Erection of 3 No. dwellings, 1 No. detached garage, parking & alterations to existing access & driveway (resubmission following BR/200/16/PL).

Land to rear of 41 - 47 Pevensey Road Bognor Regis

Thank you for your internet representation made on 6th June 2018 which has been recorded as '**an objection**' with the comments as follows:

Proposed Elevations

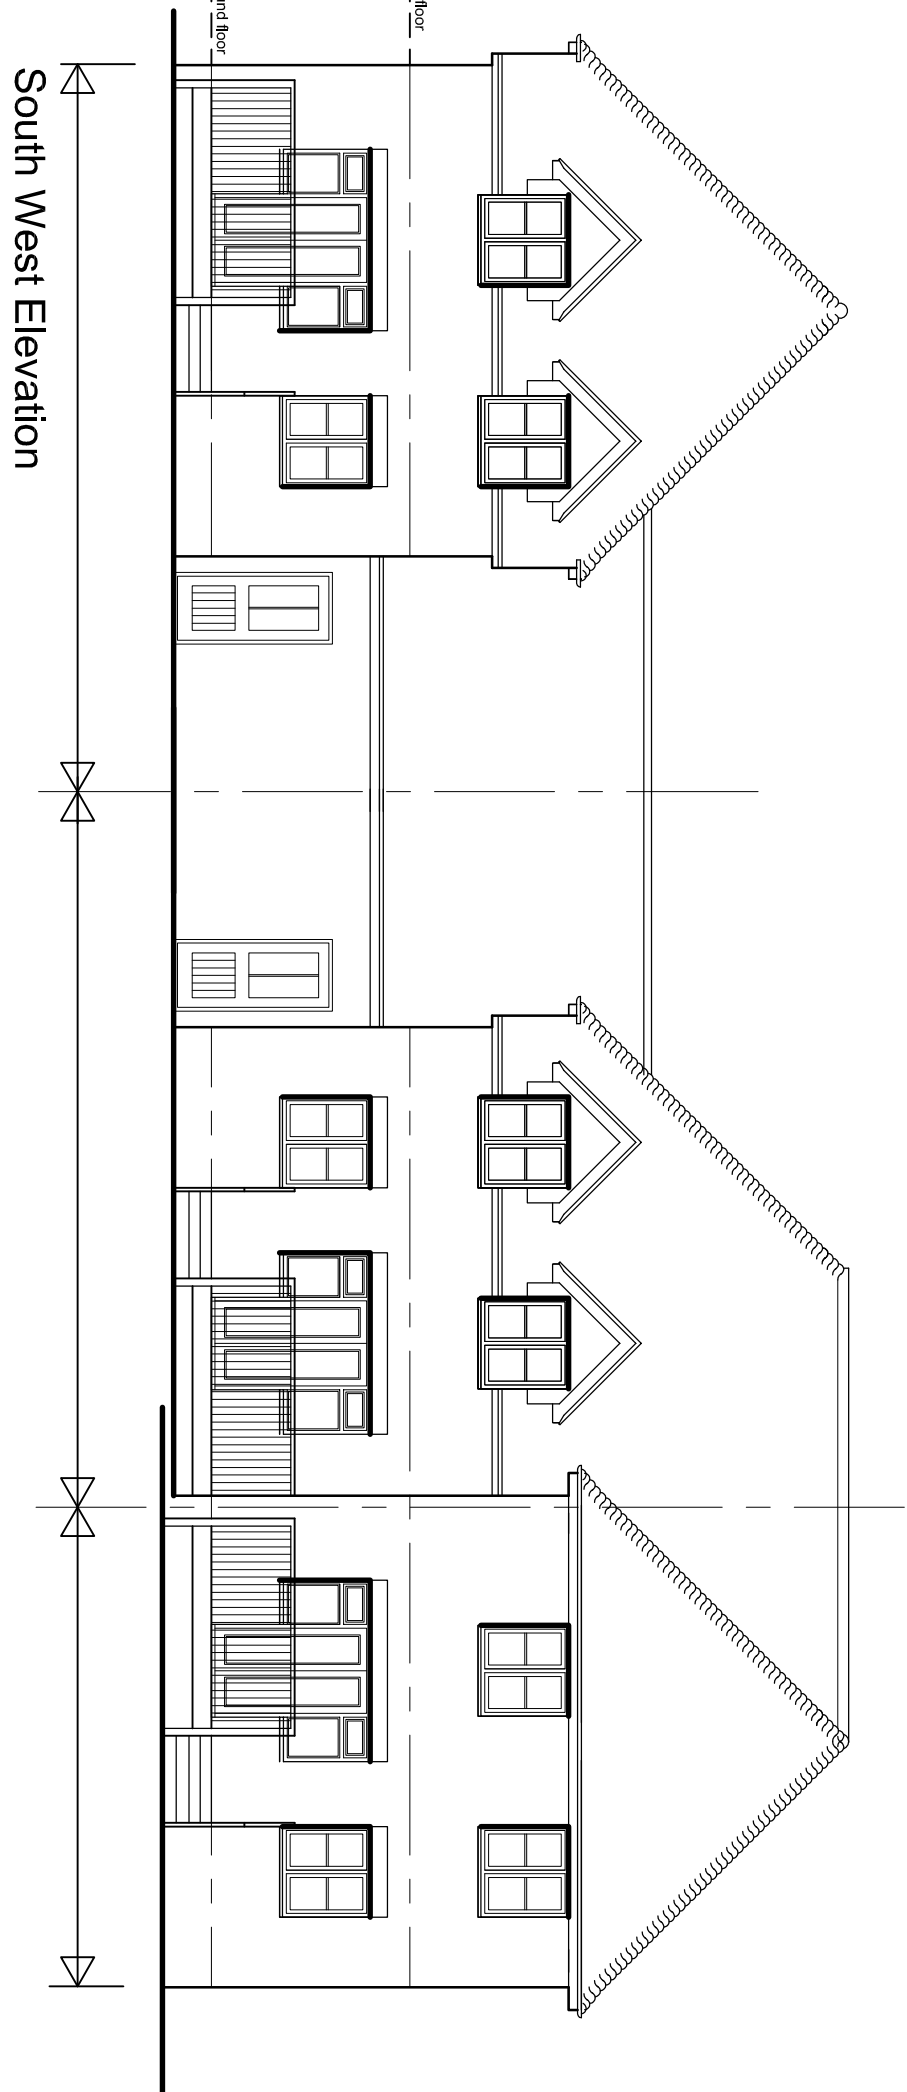
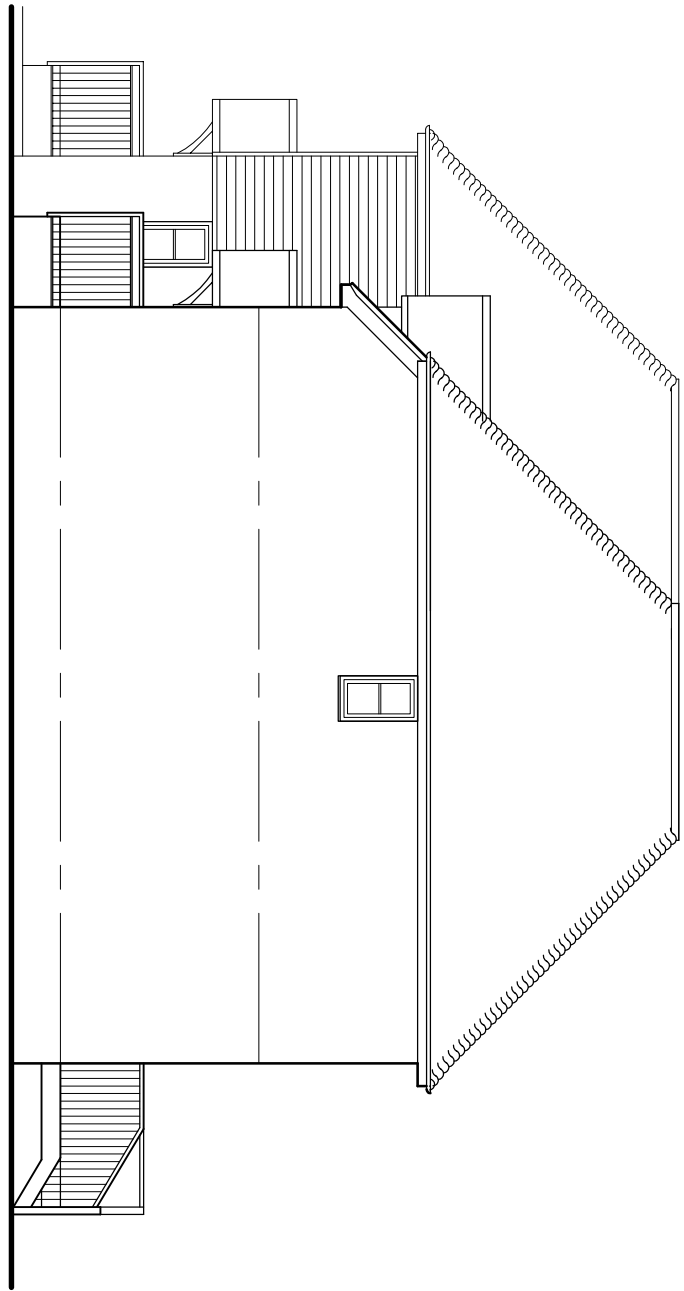
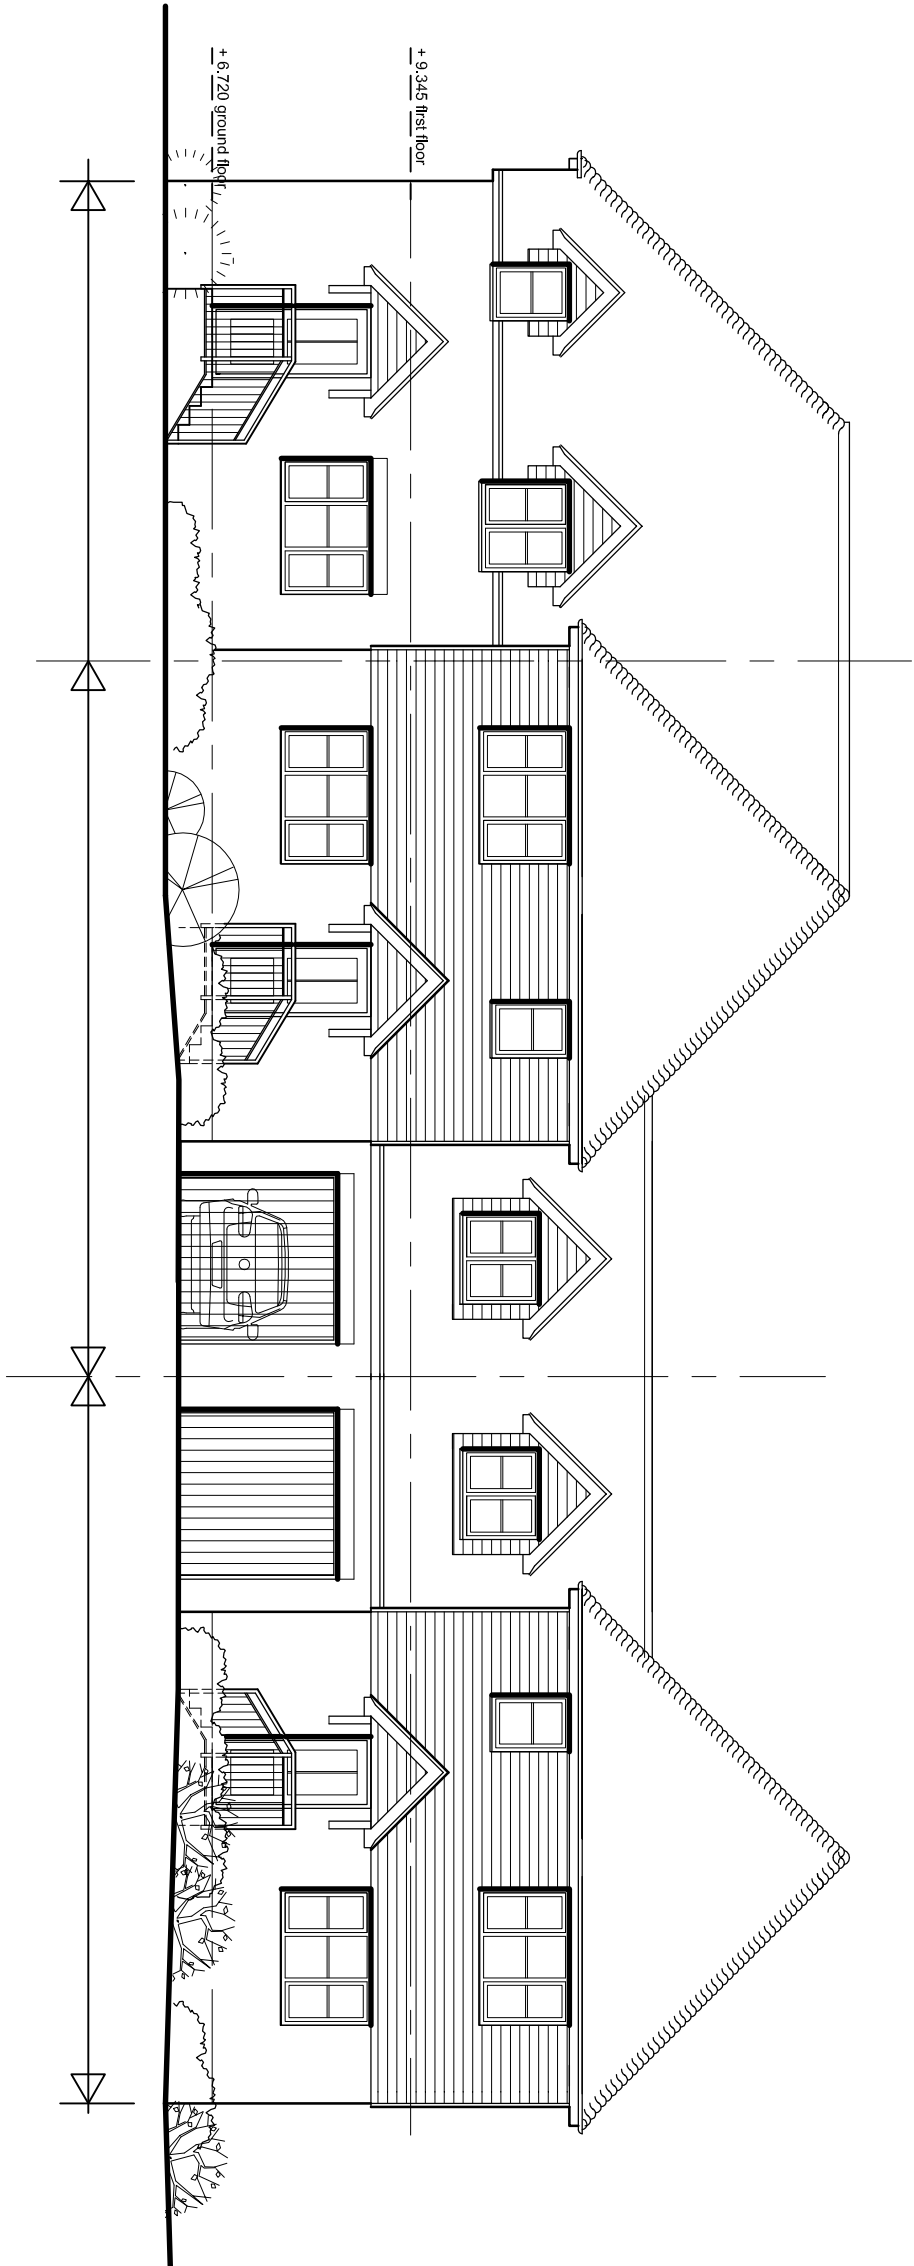
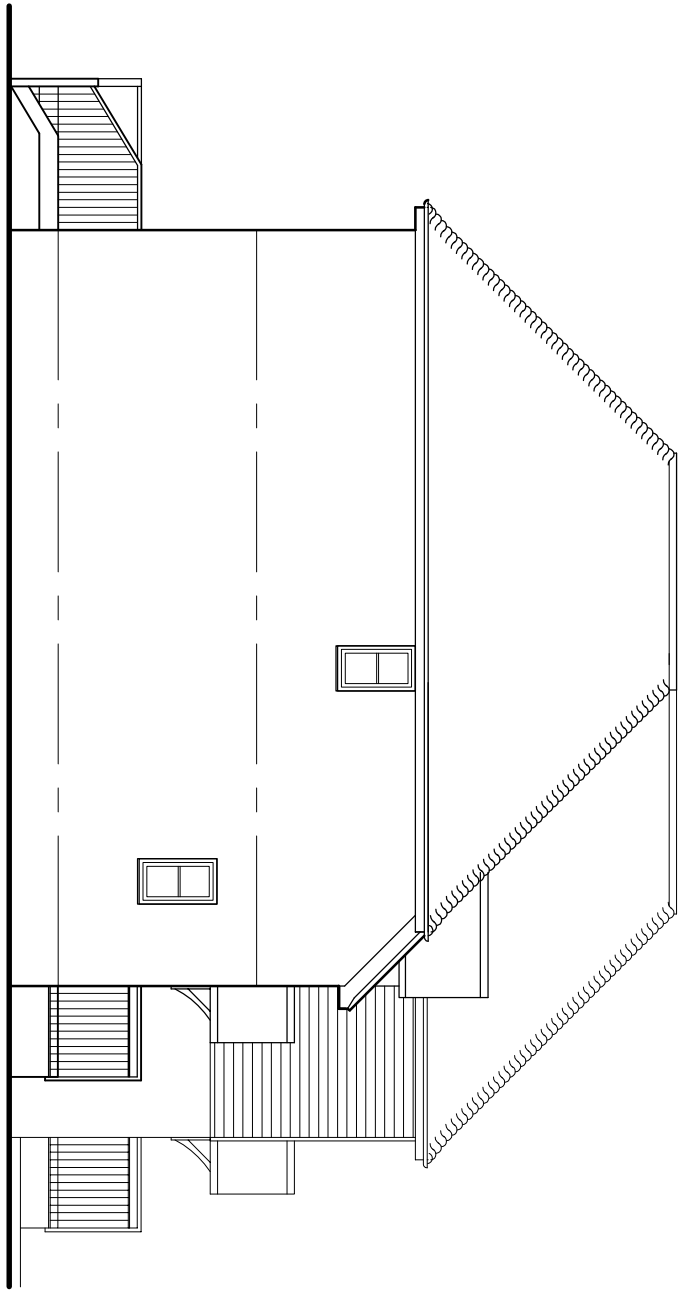
We note on the plans the new proposed houses will have to be taller than others in the area due to the flooding issues this immediate area has, their windows and doors would be higher and also by the looks of it raised decking in their gardens with steps up to get into their back doors, so number 24 and 26 Arun Road would feel very overlooked also the garden of 39 Pevensey road.
